# CITY OF MERCER ISLAND

### Pre-Application Meeting (PRE21-023)

<b>Site Location:</b>	6610 East Mercer Way		
<b>Lot Size:</b>	50,094sf	<b>Zoning:</b>	R-15 (Single Family)
<b>Brief Project Description:</b>	Subdivision of 1.15 acre lot into 2 lots and demolish the existing house and driveway.	<b>Documents Provided:</b>	Survey, project narrative and questions, plan set, pre-app application, and arborist report.
<b>Applicant Information:</b>			
<small>Name:</small>	John Anderson	<small>Email:</small>	johna@paceengrs.com
		<small>Phone:</small>	425.449.2511
<b>Second Pre-application Meeting Required:</b>	Not Applicable	<a href="#">Click for explanation if necessary</a>

SHEET **C1.0**

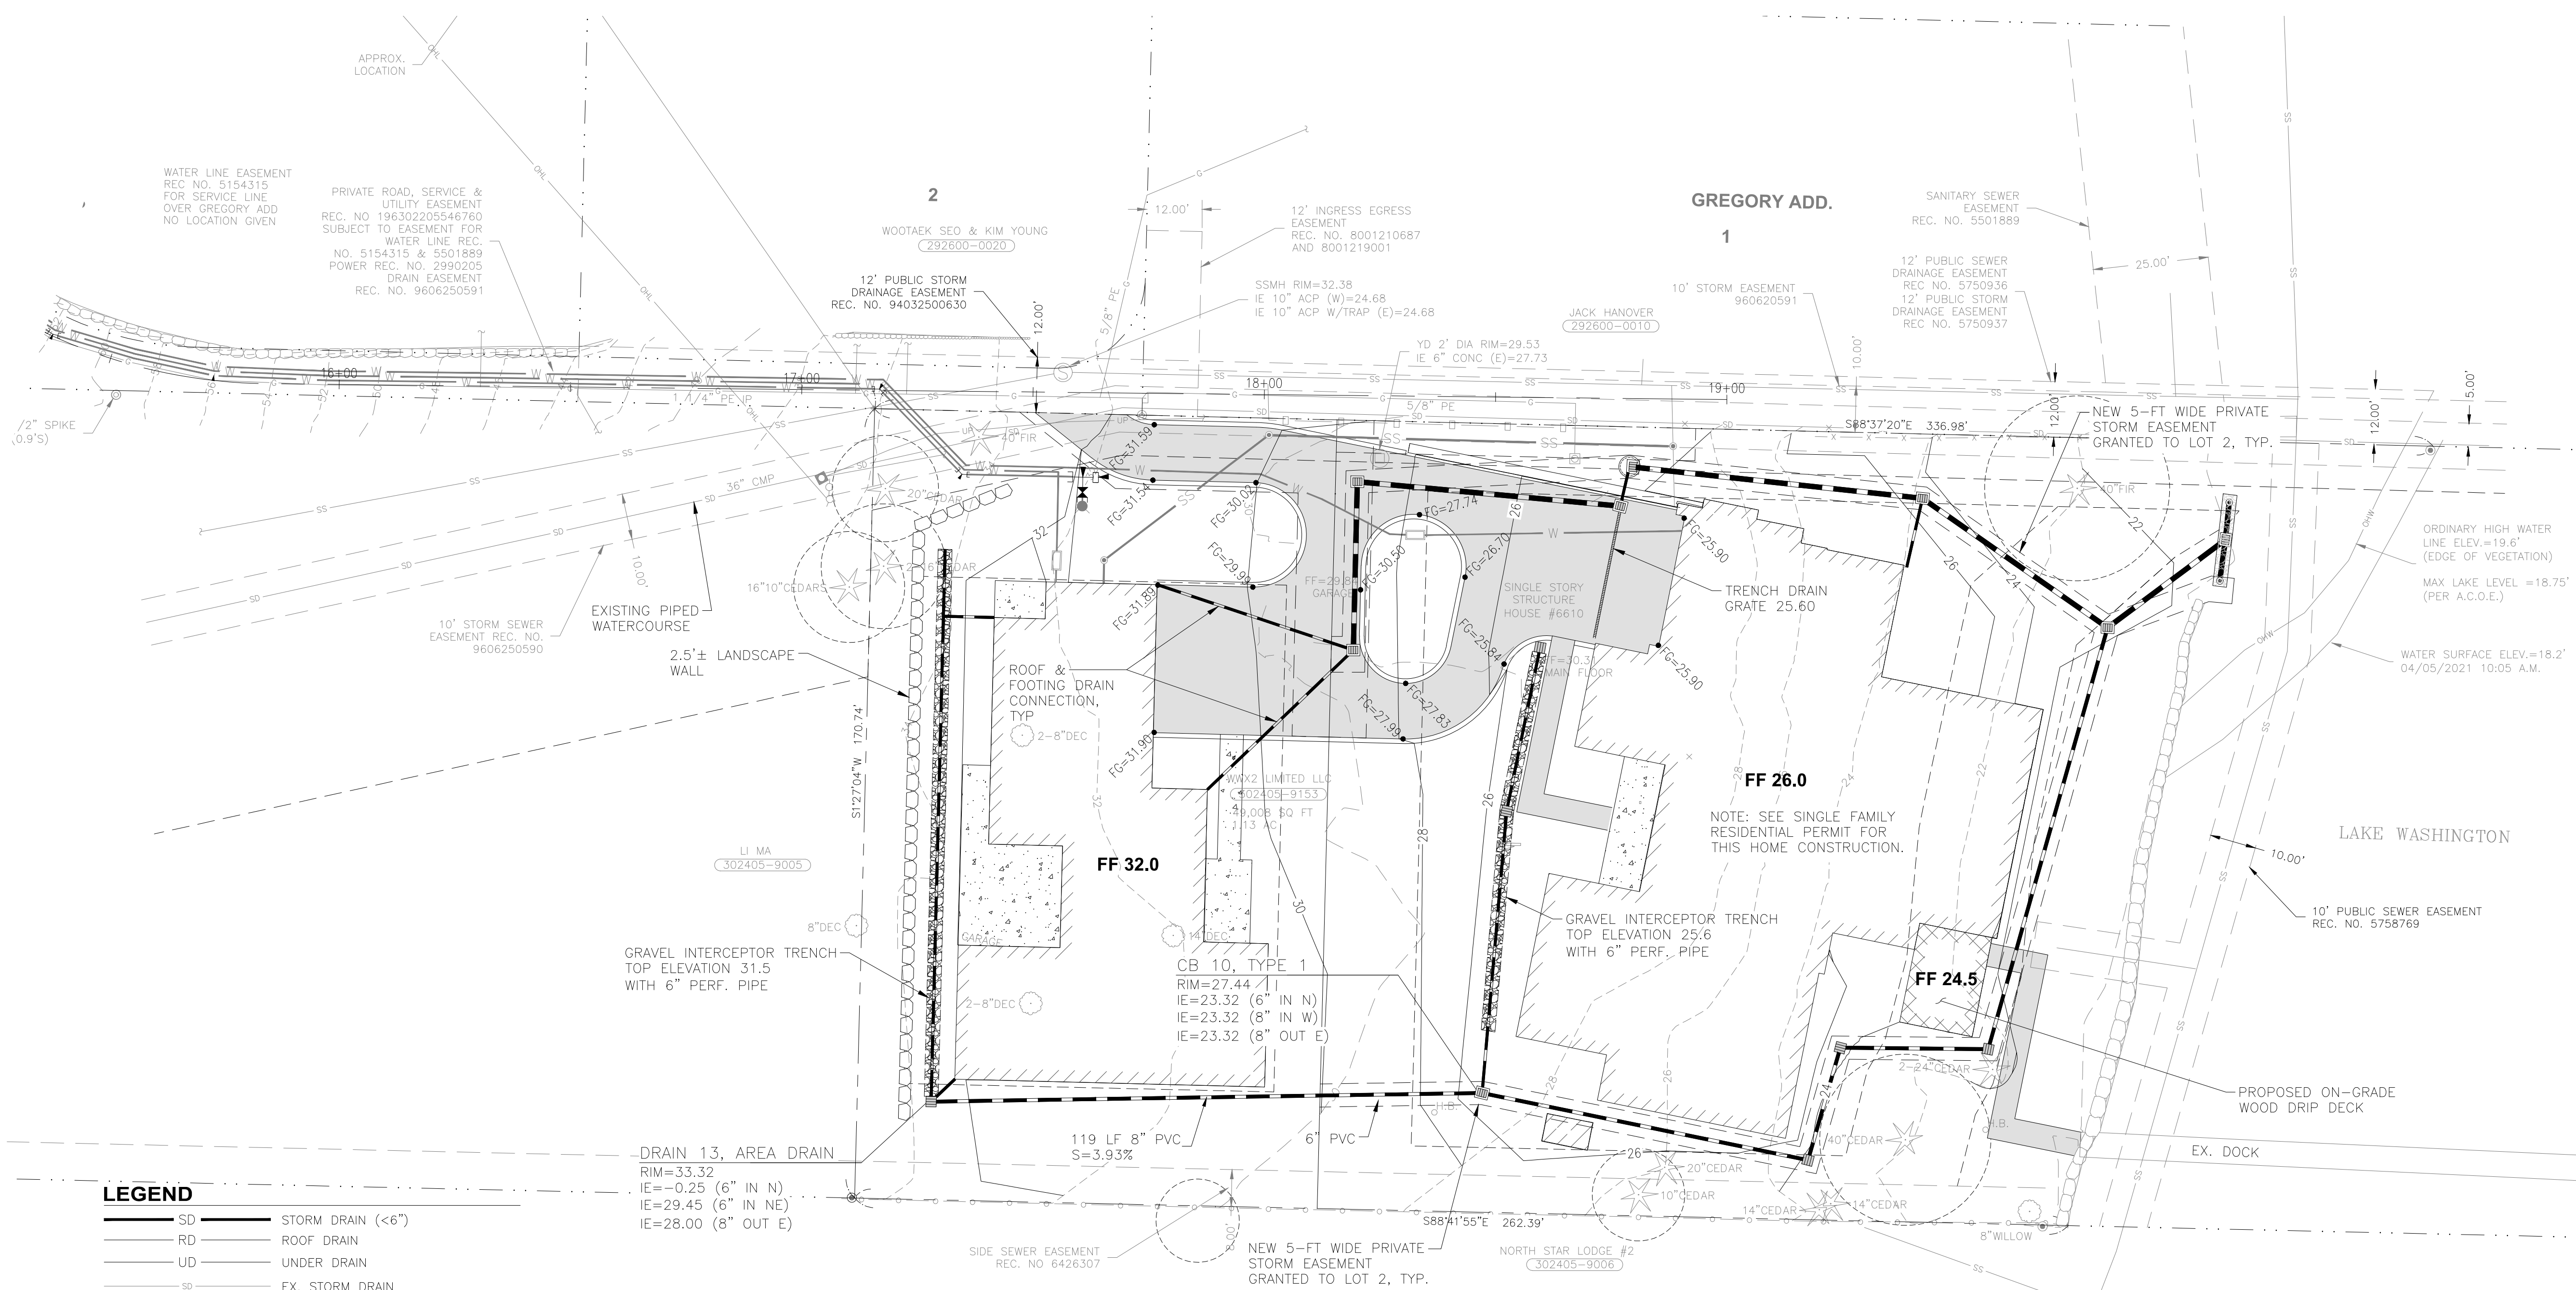
8. Do the front, rear, side and shoreline setbacks on the preliminary short plat drawing meet R15 zoning requirements?
- a. City Planner, Lauren Anderson, response: Lot 1 yard setback locations appear to be correct. The setback locations of Lot 2 may be incorrect and will depend on how the lot will gain primary access. If Lot 2 gains primary access from the north, the front yard would be from the northern property line. Please see Planning comments about required yard setbacks below.

- It is unclear how the minimum side yard setbacks were calculated, as they appear to be larger than required – please refer to the Planning comments below about yard setbacks and MICC 19.02.020(C). The minimum side yard setback is based on lot width. For a 90 foot wide lot (i.e. Lot 2), the sum of the side yards’ width shall be at least 15 feet and the minimum side yard is 5 feet. Please note this is for determining the short plat building pad only. When submitting a future building permit the variable side yard setback standards would apply and the minimum side yard setback will be based on proposed building height.*

The plans provided did not illustrate how the lots were going to be accessed (i.e. an access easement on Lot 2 for access to Lot 1) and the proposed driveway locations, thus staff was unable to confirm setbacks for Lot 2.

- d. Lot area, width, and depth standards:
- i. R-15: The net lot area shall be at least 15,000 square feet. **Lot width shall be at least 90 feet** and lot depth shall be at least 80 feet. **The proposed lot width of Lot 2 is 88 feet, which is below the required 90 foot minimum – please adjust.**

**C3.0**

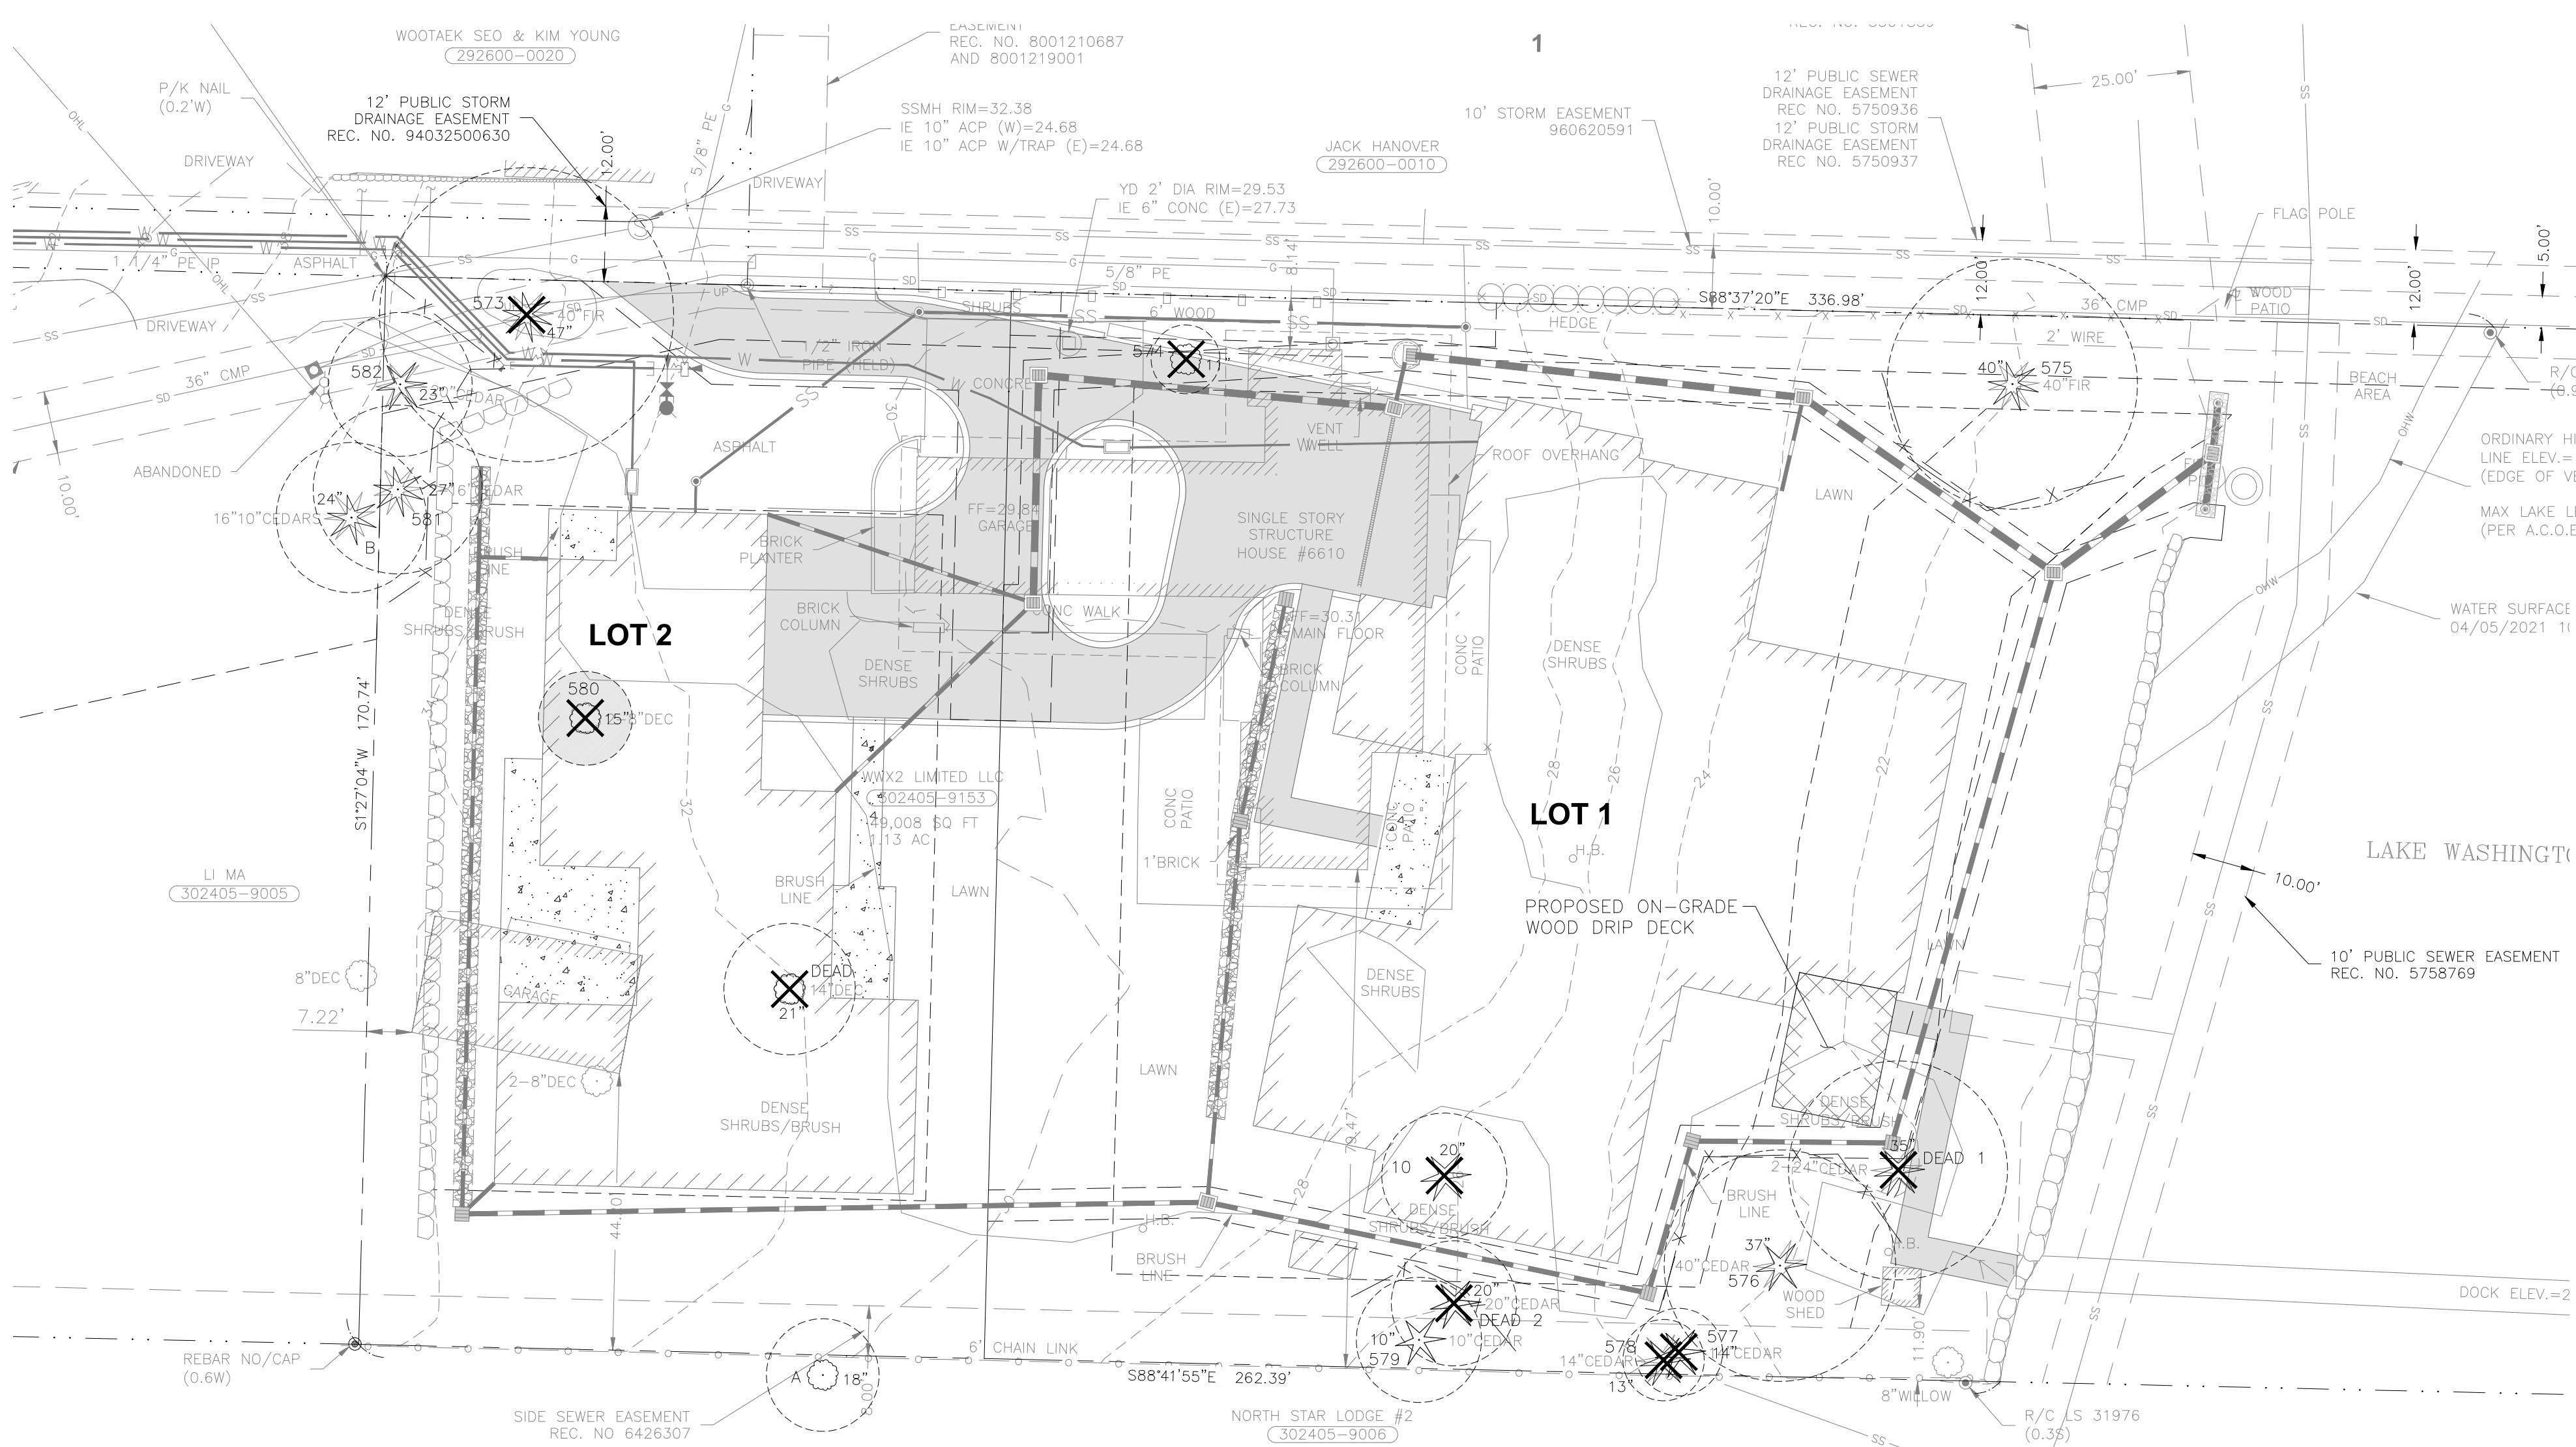
- Please see Fire and Planning comments below.*
- The existing 5/8-inch domestic water service crosses two private yards according to the City's GIS mapping. The exact location of the service line is not known. The developer would prefer to install new water meters and service lines within the existing access road easement and avoid trenching through private yards. There appears to be room near the northwest corner of property address 6464 to set two water meters along the existing pavement edge. Water service lines would be extended approximately 550 feet within the private road easement to serve the short plat lots. Is the proposed water service design described above acceptable to the City?

- Senior Development Engineer, Ruji Ding, response: The concept of the placements of the water supply lines, water meters and water service lines are acceptable. However, the city public works will determine the actual locations of the water meters and water service lines after the building permits are submitted. For submittal, show the water main on the survey and easement limits.*
